RE: Application by Cory Environmental Holdings Limited (CEHL) for an Order Granting Development Consent for the Cory Decarbonisation project.

Buglife would like to make the following additional representations in response to the additional information submitted by the applicant. Buglife maintains the points raised in our last submission dated 26th November 2024. These comments relate only to the new information provided.

Off-site Ecological Requirement Delivery Options

FIGURE 1 OPEN MOSAIC HABITAT OFF-SITE DELIVERY OPTIONS

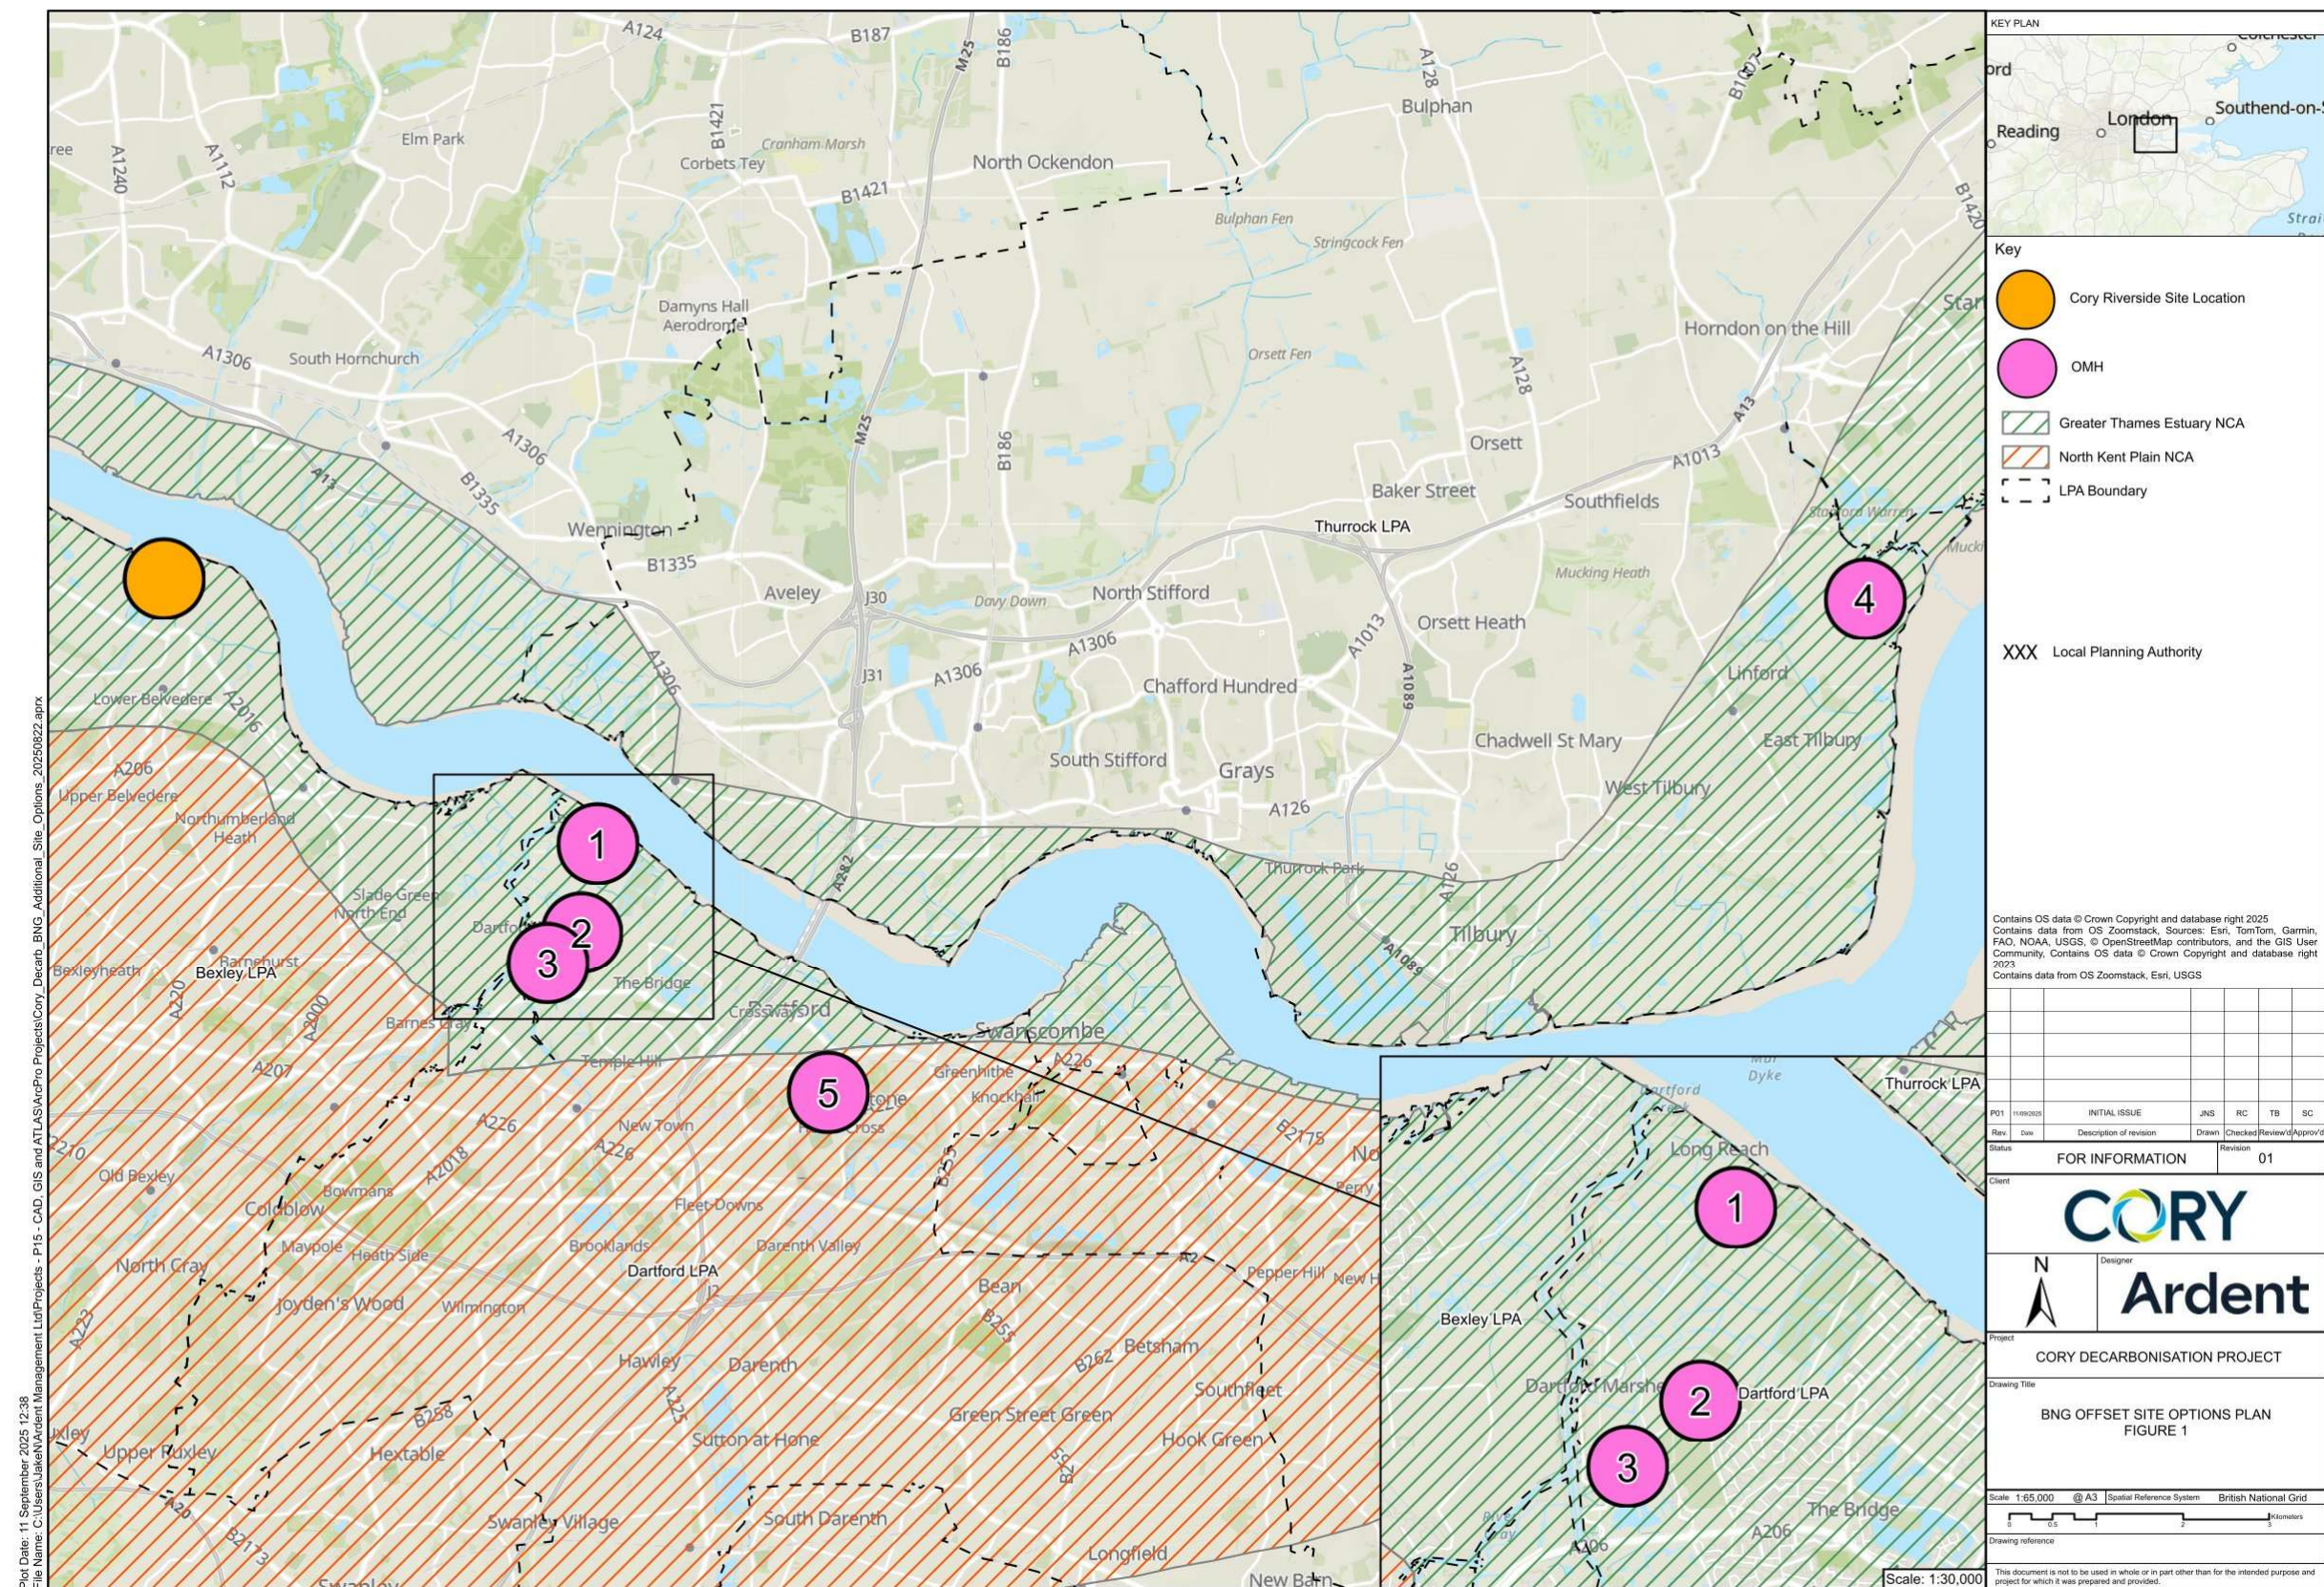
An offsite option to deliver one larger area of OMH at Thamesmead Golf Course may be more beneficial and Buglife welcomes that the applicant is still aiming to secure this site for any off-site BNG provision. Regarding other sites identified for potential off-site delivery of OMH, it is important to establish the current habitat baseline, including value for invertebrates, to ensure that habitat creation would bring genuine biodiversity uplift. For this reason, Thameside Nature Discovery Park is not suitable as it has both already been secured as off-site delivery for ecological restoration by multiple other schemes and already supports important habitats and species present.
